**Your Ref:** OWPC1380  
**Our Ref:** AB/105/13/L 24-09-2013  
**Please ask for:**  
Mr P Cleveland

Application for Listed Building Consent for redevelopment and conversion of the former Bevin Bevin site to provide 7No. apartments and 6No. houses with associated car parking

Bevin Bevin & Co Ltd River Road Arundel

Drawing
**Location Plan
Site/Roof Plan**

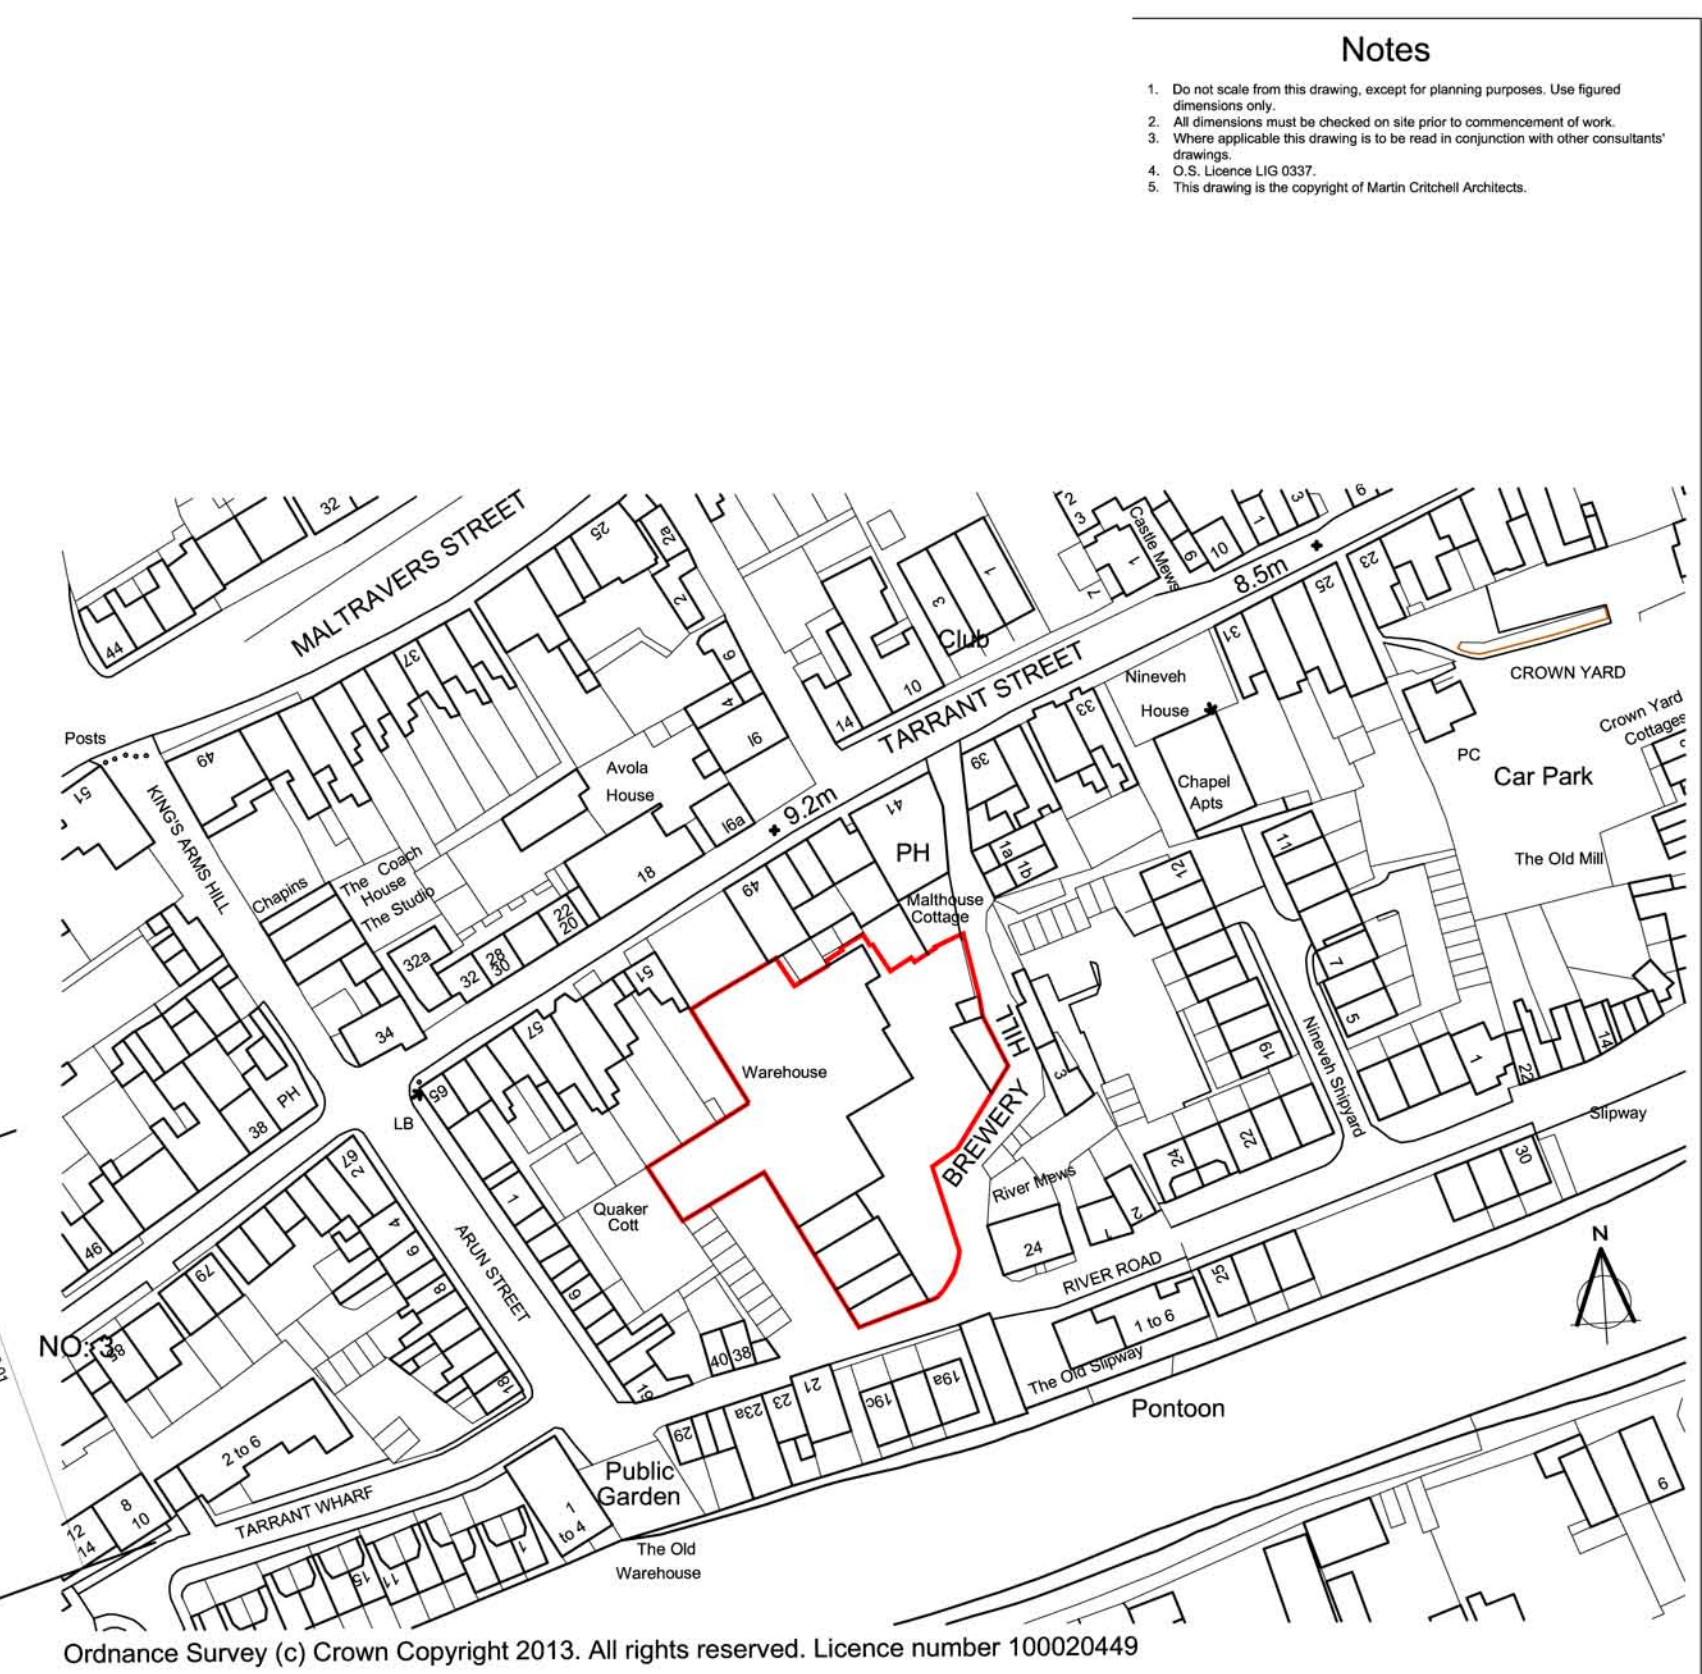
*We are writing to object to planning application REF AB/105/13/L, with particular regard to Plots 12 and 13. From the plans, the building (both the main structure and roof) appears to be (no measurements are given) a third of the wall's current height higher than the current wall (which is approximately 18 feet, thus another 12 feet higher than this wall) against which the plots are planned.*

*The distance of our house, No. 3 Brewery Hill, to the corner of the wall where the proposed plot will finish is only 15 feet 9" feet. Our second bedroom, which also acts as a home office, directly looks out to that corner. Thus the distance between our bedroom window and proposed plot 13 is only 15 Feet. The height of building plot 13 will, therefore, seriously limit the light into the bedroom, while we will also experience a real sense of enclosure.*

*The kitchen window, directly underneath this bedroom also looks out on this corner and to the part of Brewery Hill which leads to the entrance of Bevin and Bevin's yard. With the extra height of plot 13 above the current wall, we will suffer serious loss of light to the kitchen and will also experience being enclosed too.*

*The planned depth of building plot 13, running alongside the eastern aspect of the wall (facing South) appears to end at the end of our courtyard Garden. Given its height above the current flint wall of the yard, we will experience enclosure when being in our garden as the distance between our garden wall and the current wall (against which building plot 13 will be erected) is only 20 feet.*

*The plans do not show the eastern side of Plot 13 (looking South) and so we do not know if there are plans to have a window on this side. Should this be the case, we will also experience a loss of privacy.*

*We note the very close proximity and height of plots 13 and 12 to our home, an 19 century, Grade 11 listed flint cottage; this is, to our knowledge, unprecedented in Arundel's town centre.*

*We should also comment that our cottage is often seen by visitors to the town and admired for its cottage nature, together with the historic flint wall alongside which it resides. We believe that the planned development of plots 12 and 13 will seriously affect the 'look' of this attractive part of Brewery Hill.*

*In conclusion, Plot 13 will seriously affect our light to our bedroom and kitchen and, given the close proximity and height differential of the building to our two story cottage, will create an enclosure unprecedented in the centre of Arundel.*
